# CRAIGWEIL PRIVATE ESTATE LIMITED

13/07/17

## Objection to Planning AW/155/17/PL 28 Kingsway

Existing + Proposed Street Elevation

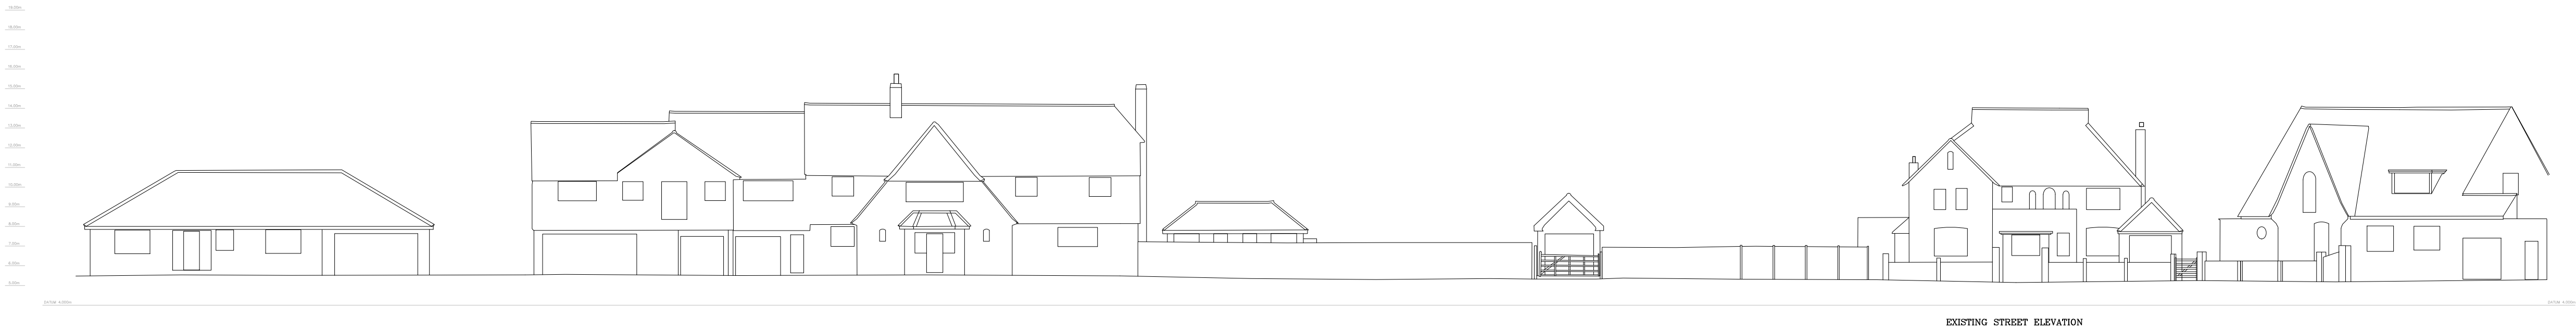
- 2 The front of the house is too near the road. What might be an acceptable building line for the cottage style houses/bungalow on each side of 28 does not mean that a tall flat-fronted house can be sited so close to the road. The front of the planned dwelling, being so far forward than the main structure of 28, would substantially affect the "street scene" viewed from the east.

- 4 The pitch of the roof appears to be more imposing than 28, in addition to being too near the road, perhaps to accommodate the attic room. A lower pitch roof would prevent the attic being turned into further habitable area (with sea views) and would safeguard the privacy of adjoining sites.

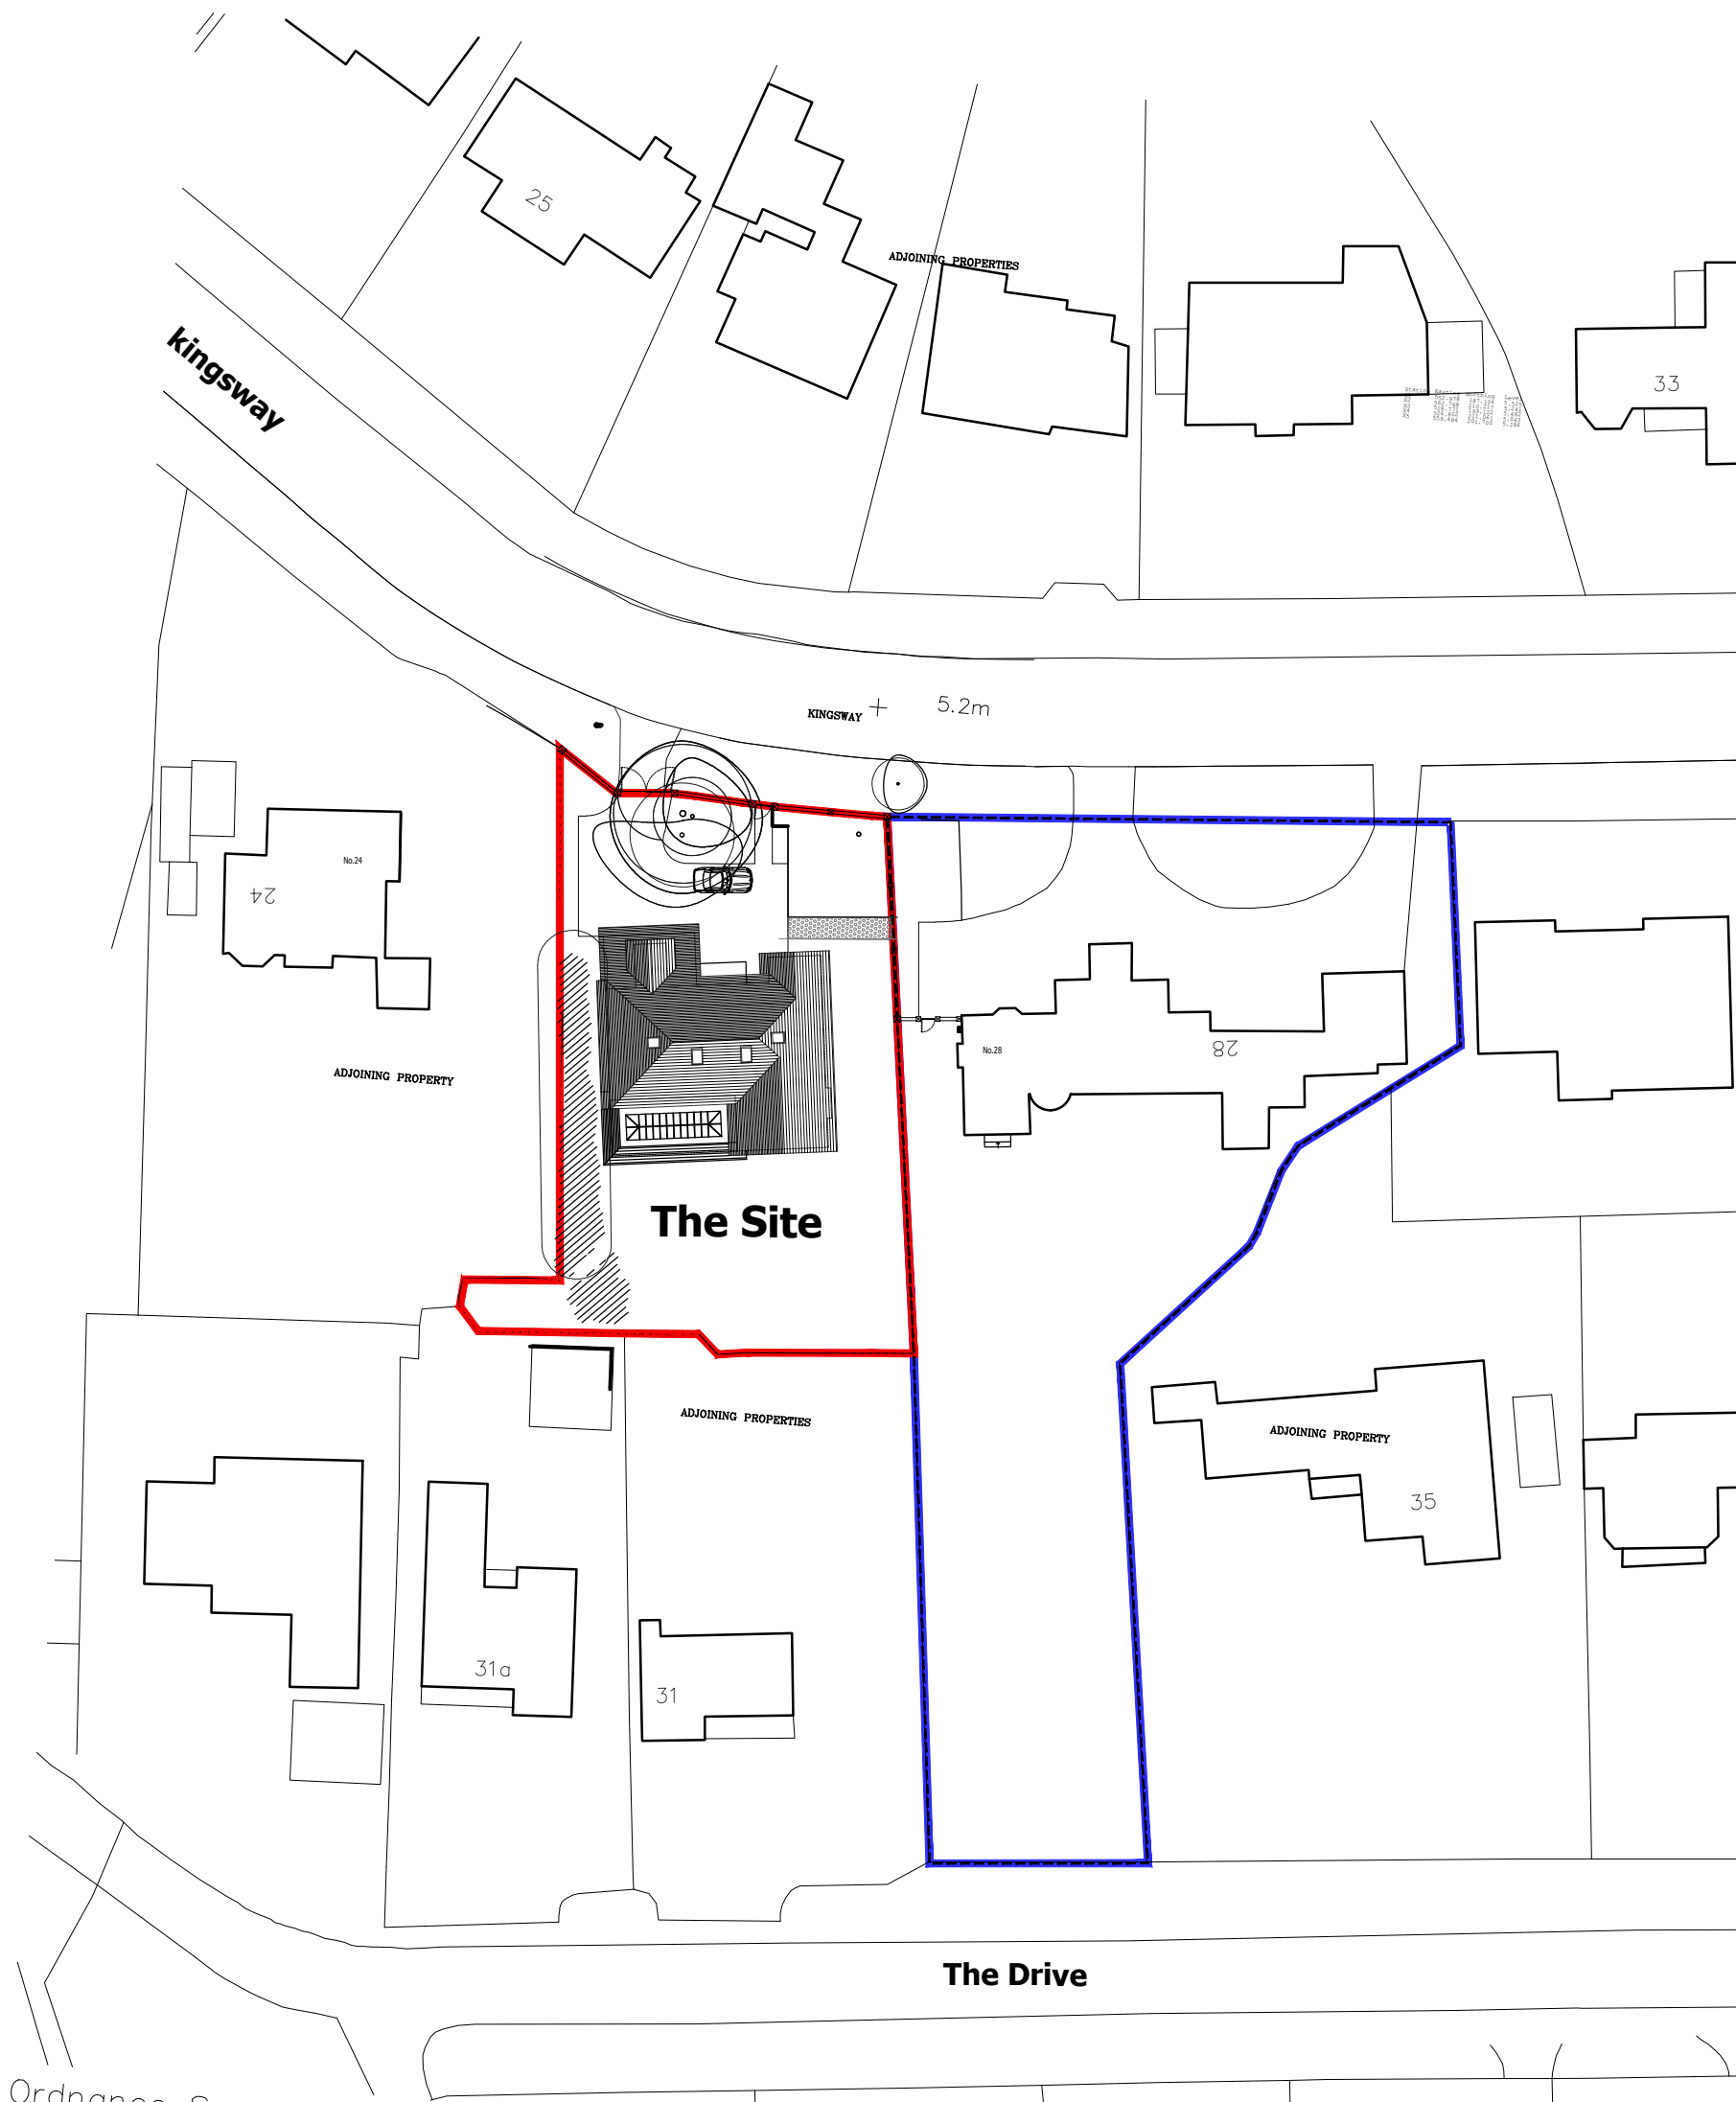
- 3 The area shown as parking for four cars is much too small. There is need for turning when all cars are parked and to have potentially many more than four vehicles belonging to the house means that some will inevitably be left on the road, which has no pathway, and therefore creates a danger.

- 6 In order to relieve space for cars to park/turn within the site it is planned to leave gates open over the verge owned by Craigweil Private Estate Ltd. This is unacceptable to the company although there is no requirement that gates be installed.

- 7 The plans show that a footpath is intended across the verge in addition to the (possibly widened) car access. Should the necessary planning application be made for this then, in view of the general rejection of the planned building, this would be resisted by the company.
